A585 Windy Harbour to Skippool Improvement Scheme

8.3 Draft Statement of Common Ground with the Environment Agency

**STATEMENT OF COMMON GROUND WITH THE
ENVIRONMENT AGENCY**

Version	Date	Status of Version
Rev 0	May 2019	Deadline 2 Submission
Rev 1	July 2019	Deadline 4 Submission

Figure 2-2: South headwall plan

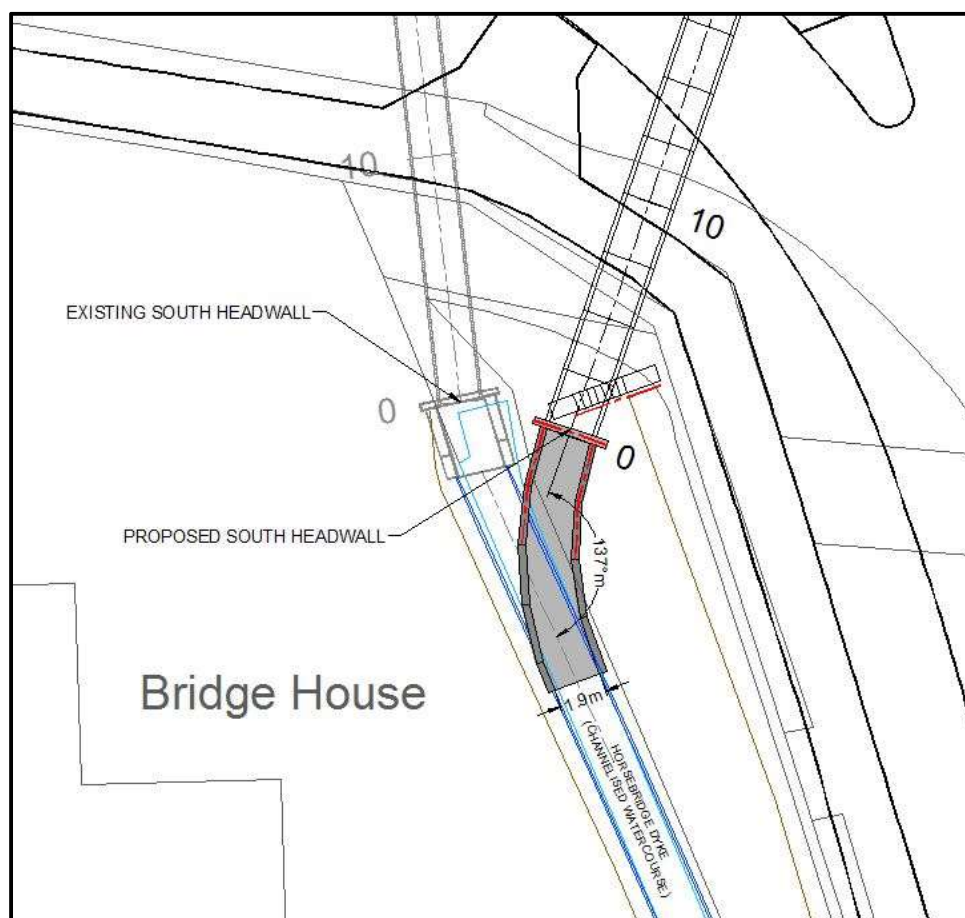
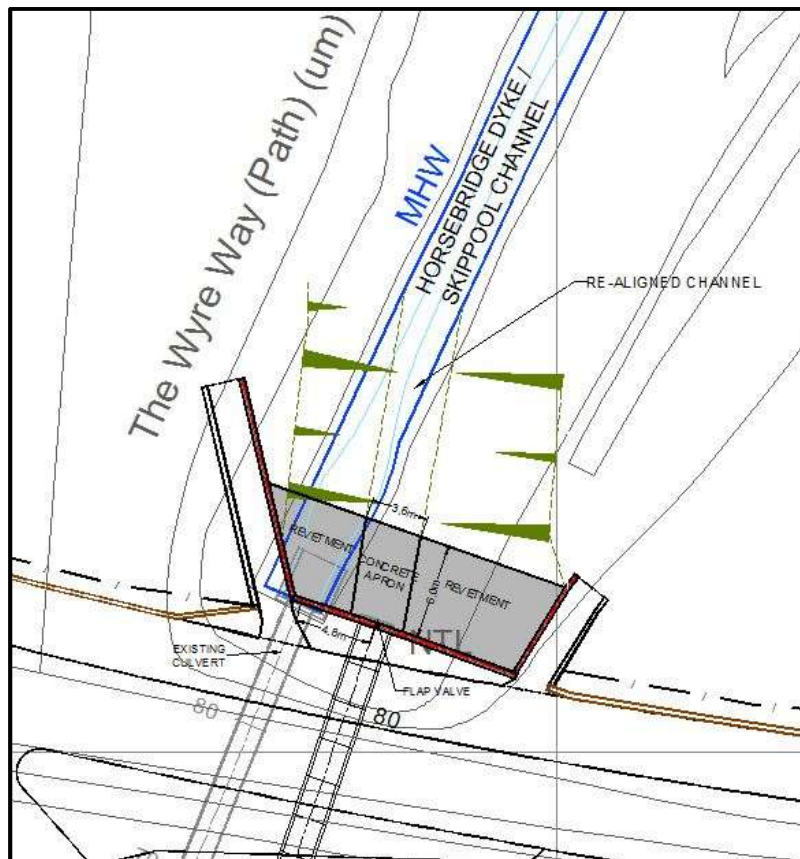
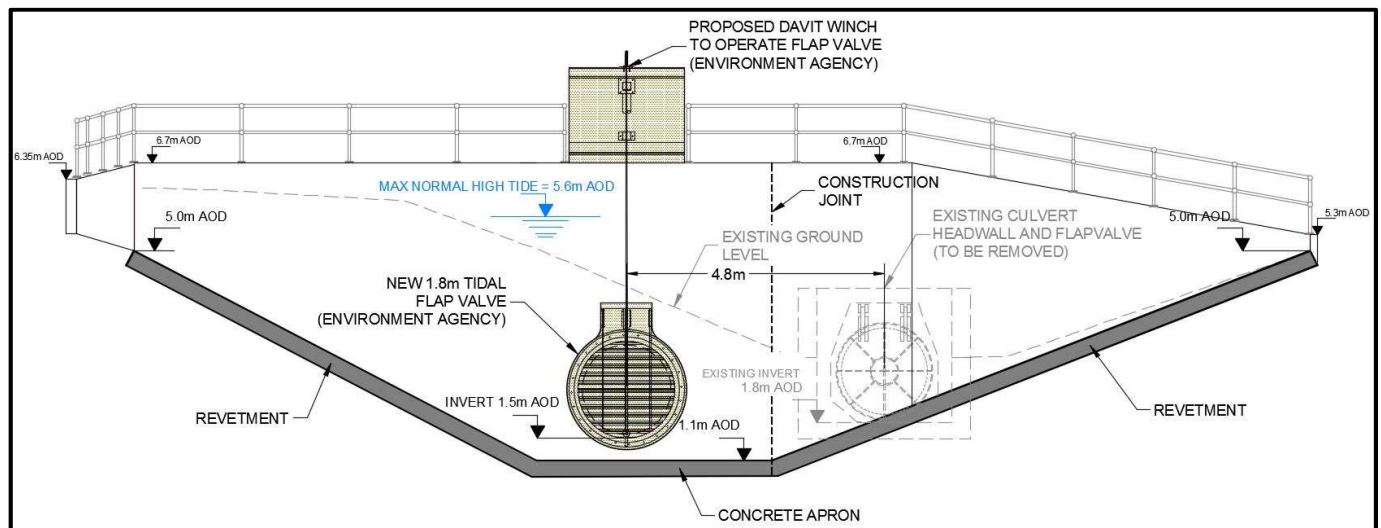
Issue/Topic	EA Comments	Highways England Response / Plan of Action
Replacement culvert – Horsebridge Dyke	<p>Clarification on the proposed replacement Horsebridge Dyke culvert needs to be provided and design of any replacement agreed with us.</p> <p>If a FRAP for this structure is to be dis-applied, detailed info needs to be submitted with the DCO application. We do not consider it to be the best approach to go down the disapplication route.</p>	<p>Further detail on the Skippool Clough (Horsebridge Dyke) culvert is included in Section 5.3 of the modelling annex submitted to the Environment Agency – 15 February 2019.</p> <p>The Project Team is seeking a meeting with the Environment Agency to discuss permitting. It is unlikely anything could be dis-applied without a Contactor on board.</p>
Modelling and investigation	<p>We have not been given the opportunity to review the ‘enhancements’ to the tidal model, but we are aware that Highways England’s consultant is currently working on this.</p> <p>An Environment Agency 2D only model of the River Wyre Estuary has been enhanced and used to assess both the risk of tidal flooding to the scheme and any change in tidal flood risk to third parties. On the basis that we have not had been provided with the opportunity to review the enhanced model, we have to take the findings and assumptions made in the report at face value.</p> <p>As such, we need to be provided with opportunity to review the enhanced tidal modelling that has been undertaken prior deciding the application.</p>	<p>The tidal model has been sent to the Environment Agency (February 2019).</p>
